Application for Planning Permission for Works or Extension to a Dwelling

Development: Dropped kerb in front of the property.
Location: 270 Chichester Road Bersted PO21 5AX

I regret that I am unable to accept your documents as a valid application until the following item(s) have been received or resolved :-

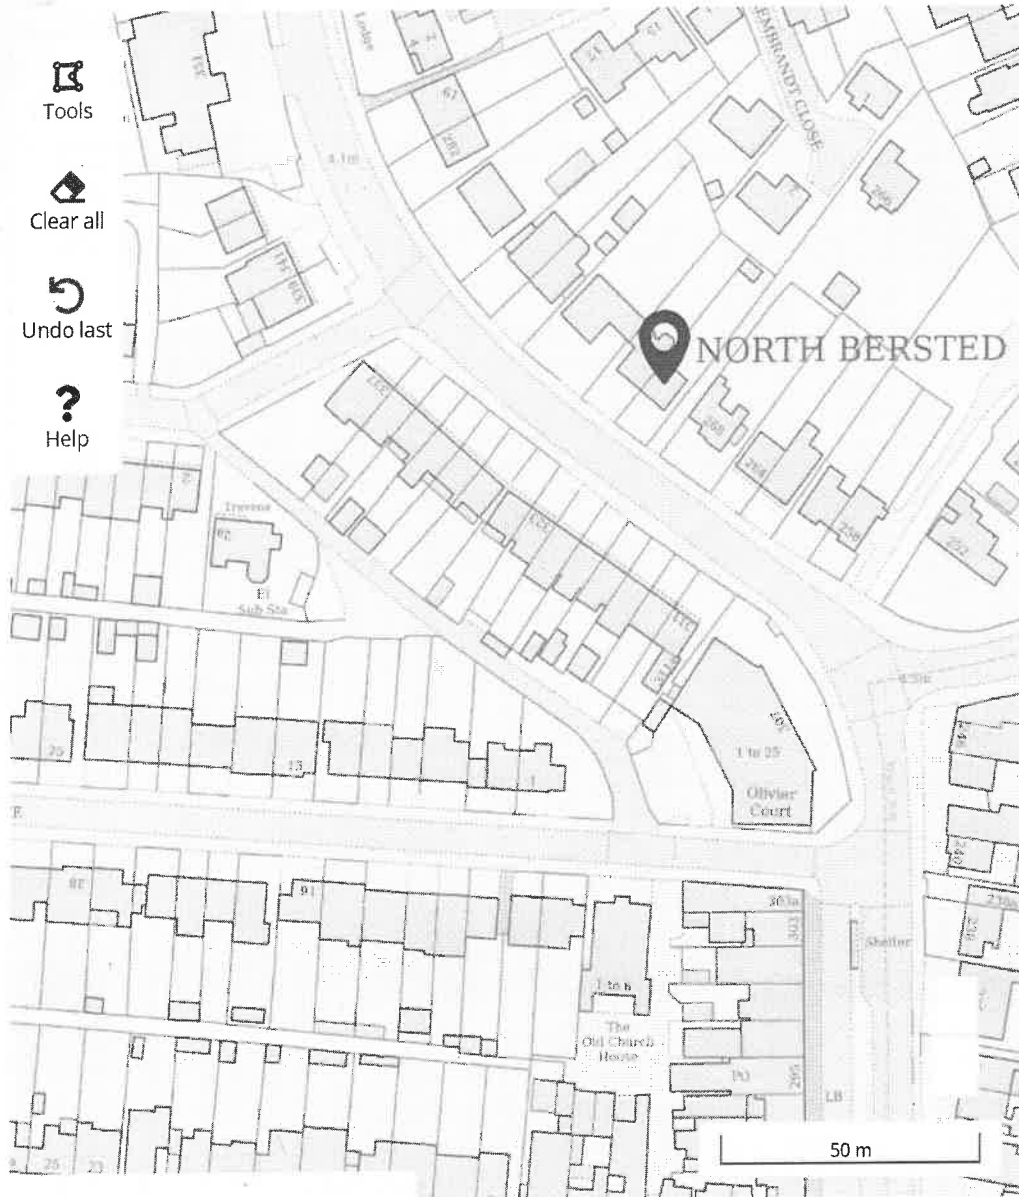
The location plan requires a solid red outline around the entire site boundary, including part of the highway where you are proposing the crossover. The current location plan excludes the dwelling itself, please review and amend.. Further details of what must be included on the plan can be found in the Validation Requirements List.
